Part 3A Revised Concept Plan and Project Application for Graythwaite (ref MP – 0149 and MP – 0150)

GRAITHWAITE PART 3A REVISED CONCEPT PLAN AND PROJECT APPLICATION
(Reference MP – 0149 and MP – 0150)

SUBMISSION TO THE NSW DEPARTMENT OF PLANNING

Level 3 overlay showing
 increased setbacks - SK 100

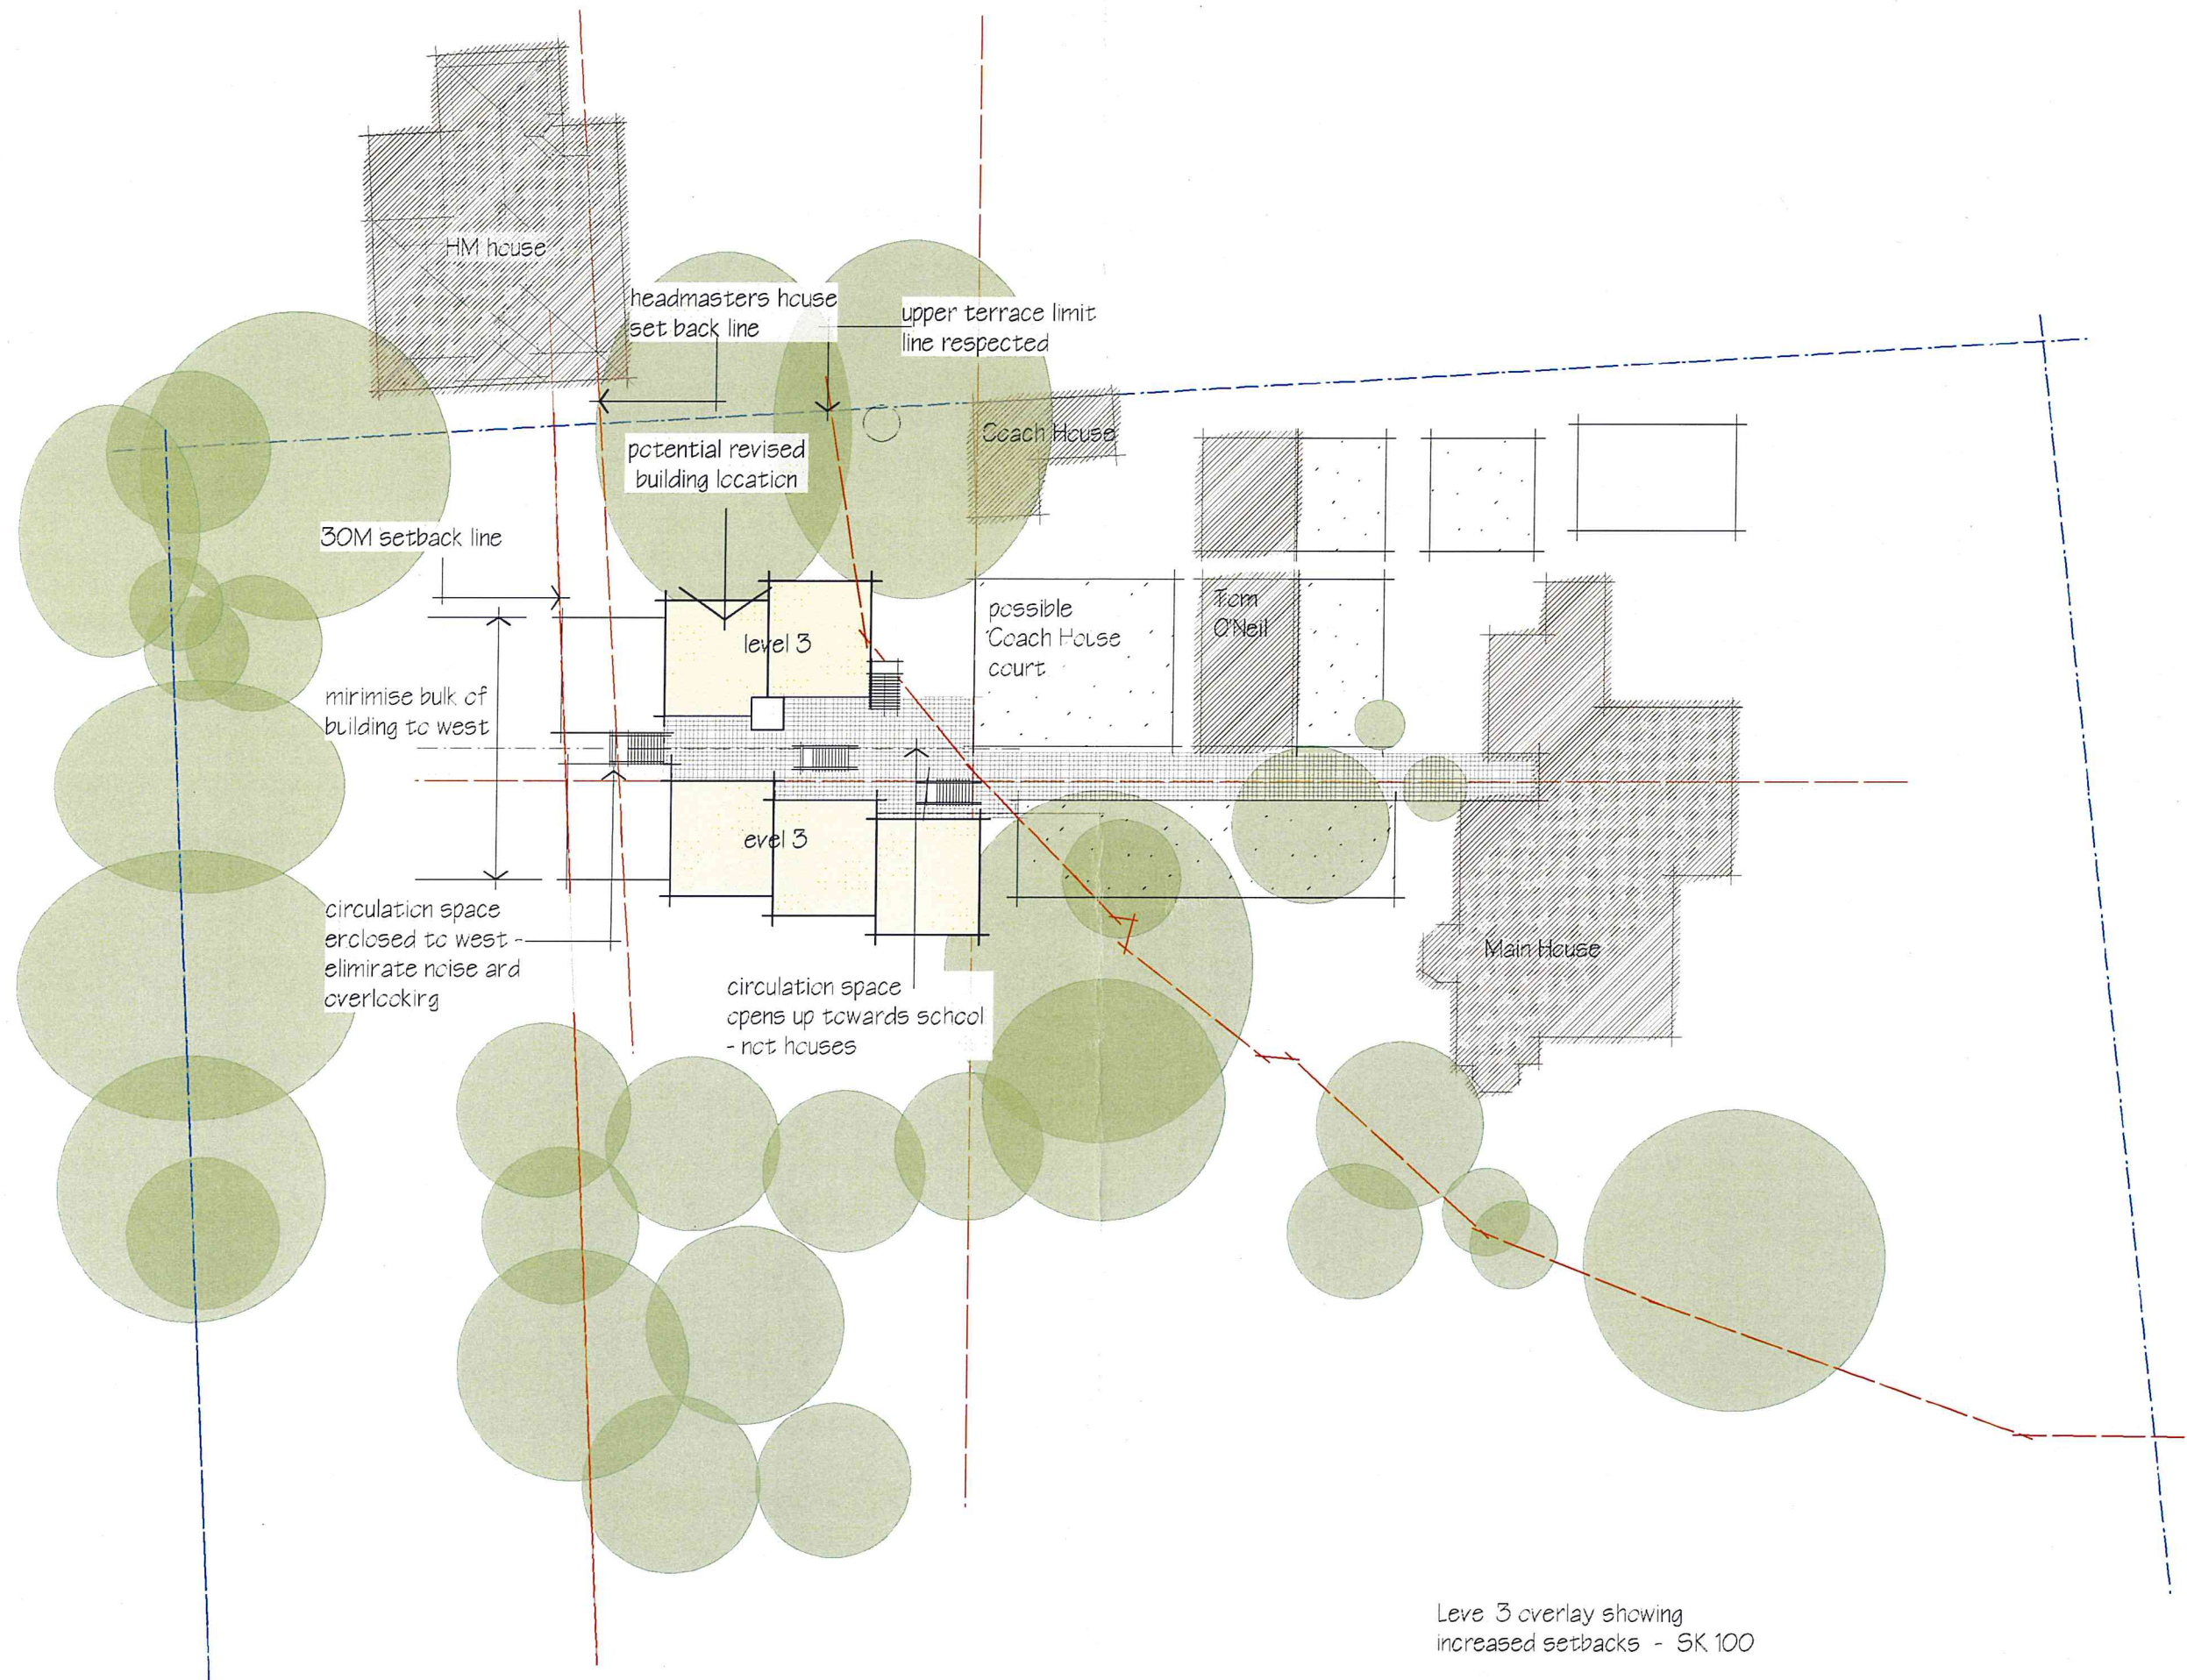
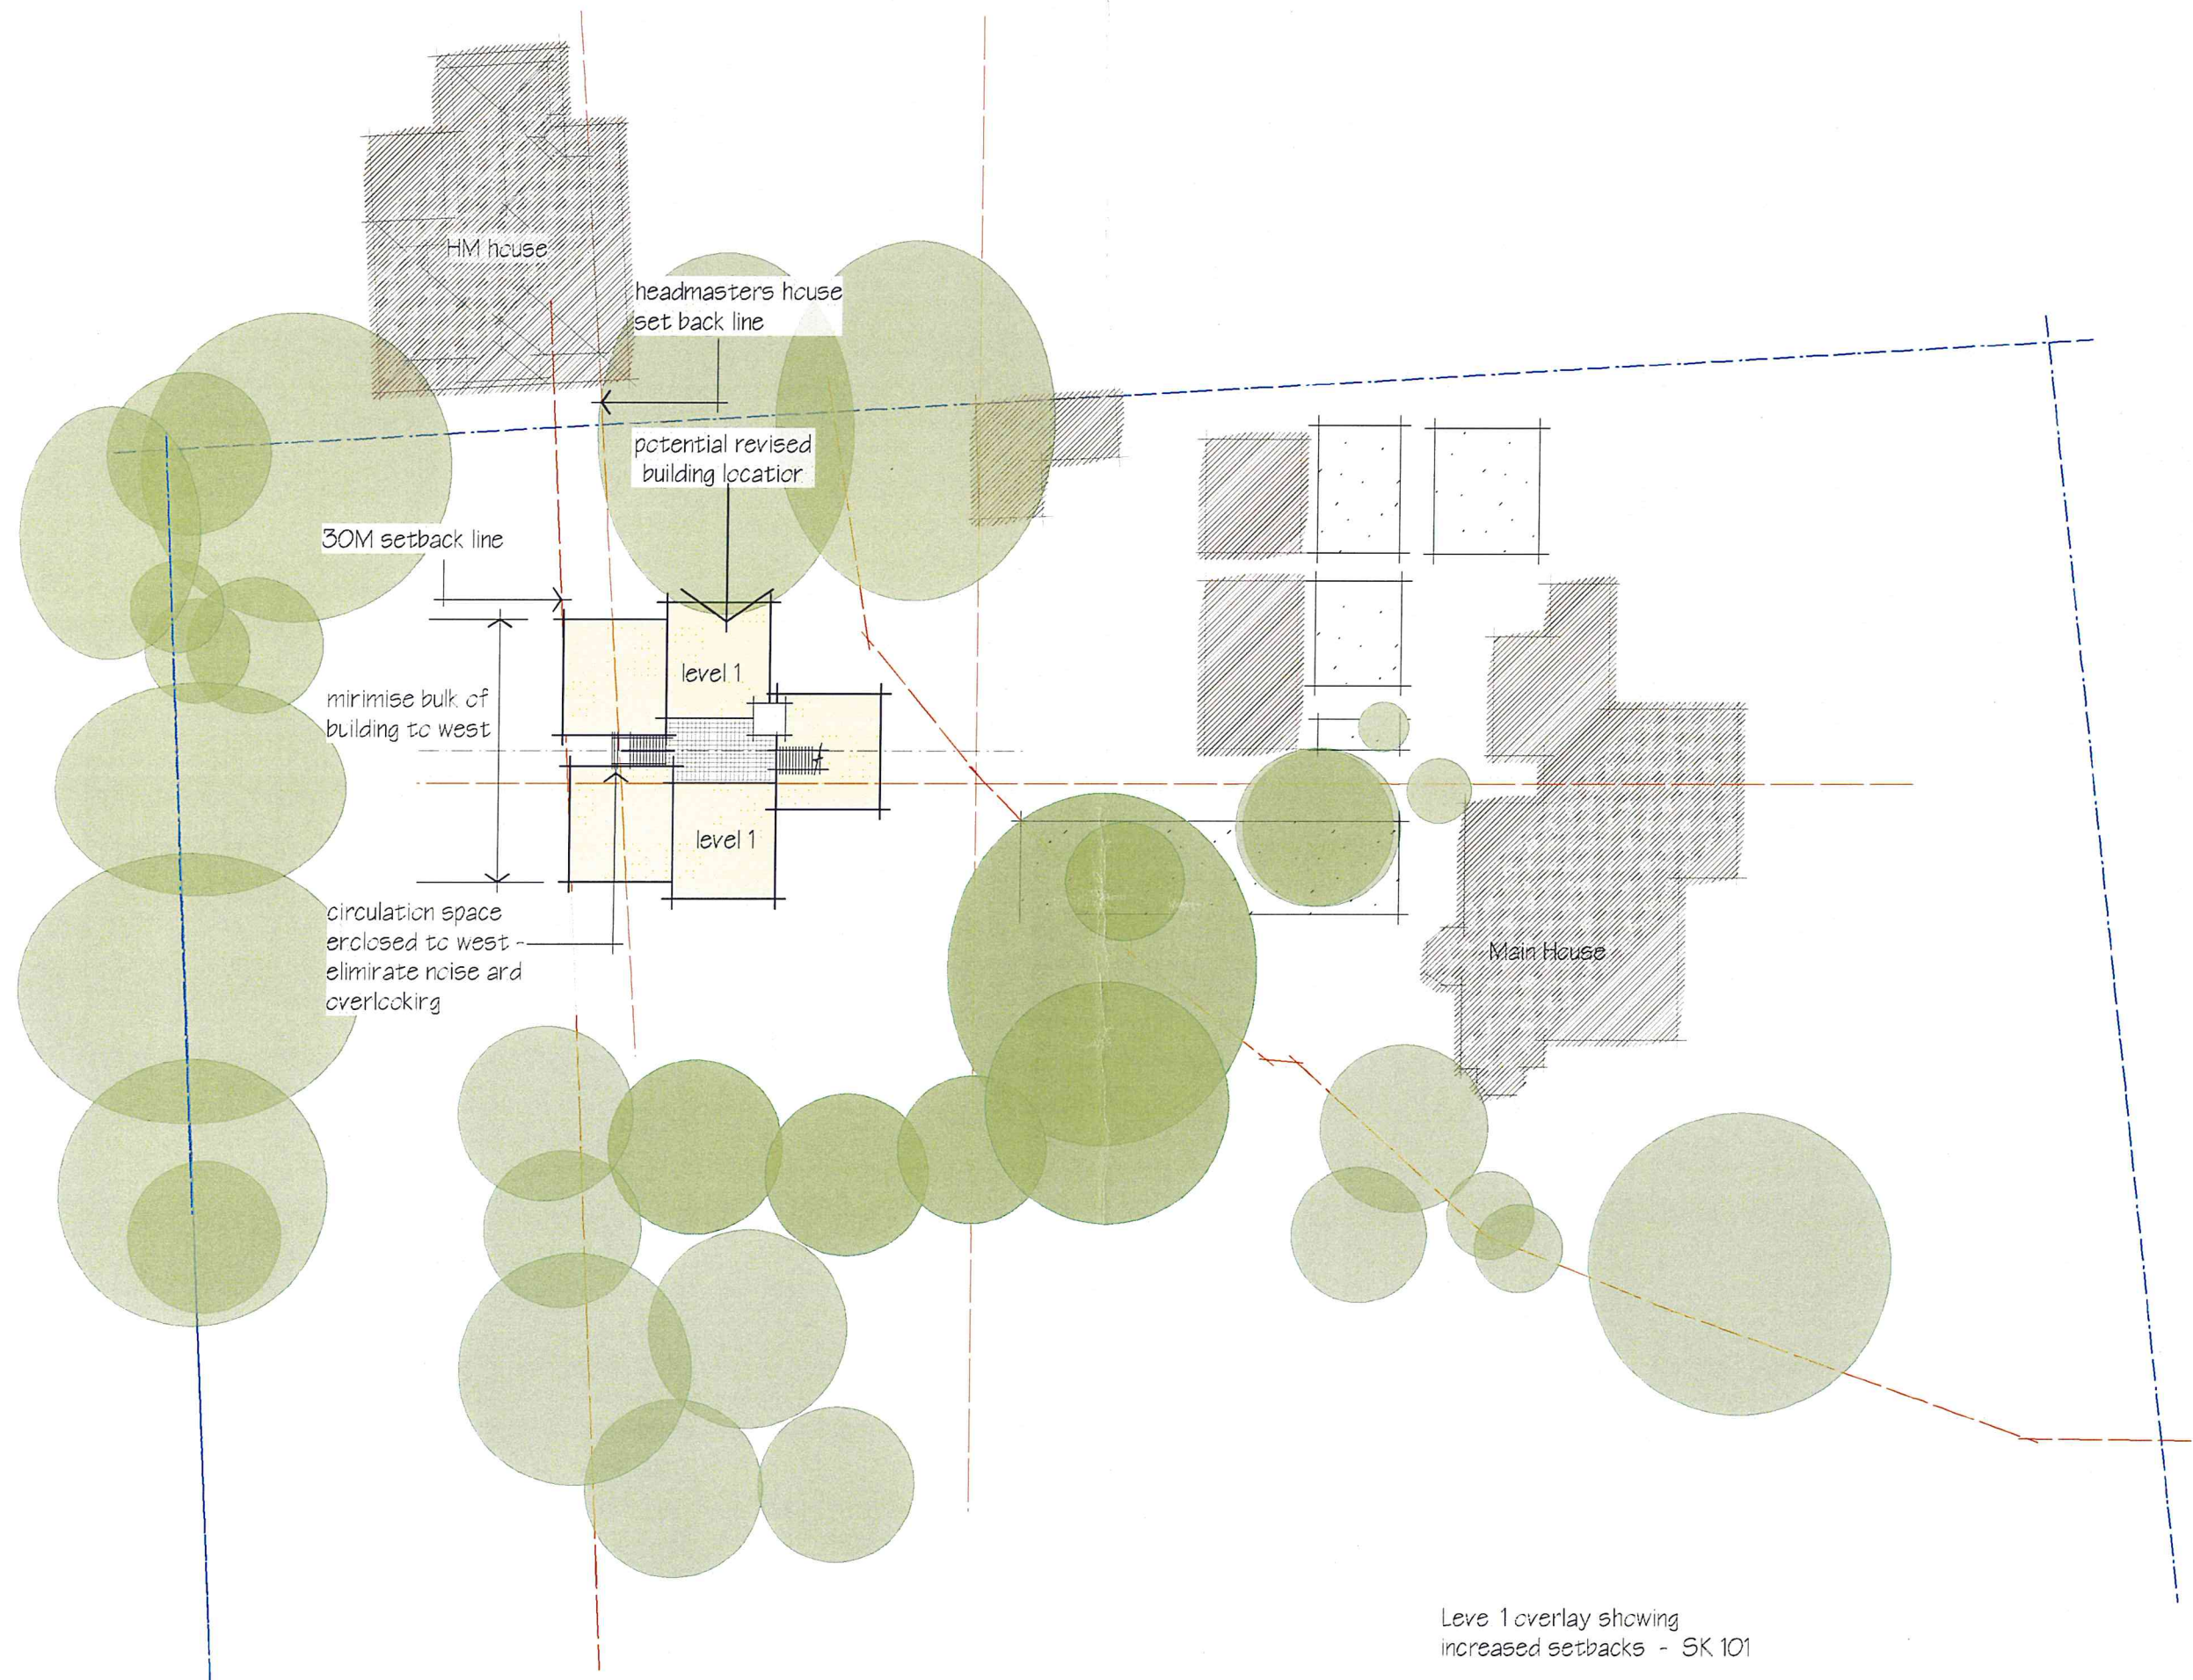
6. There has been a MINIMAL INCREASE IN THE SETBACK of the West Building from the west boundary to the adjoining residences. The northern classrooms have been setback further by only 4 metres, although this part of the building has an additional 'step' that helps reduce its visual dominance. The southern classrooms have been setback further from the boundary, but step more dramatically in a two storey increment, which fails to mitigate the visual impact. In contrast, the residents alternative proposal rejected by the School, would have resulted in a much more meaningful setback.
7. There has been a MINIMAL DECREASE in the amount of additional floor space; a decrease of approximately 400 square metres (from 5,345 square metres to 4,945 square metres), or less than 8%.
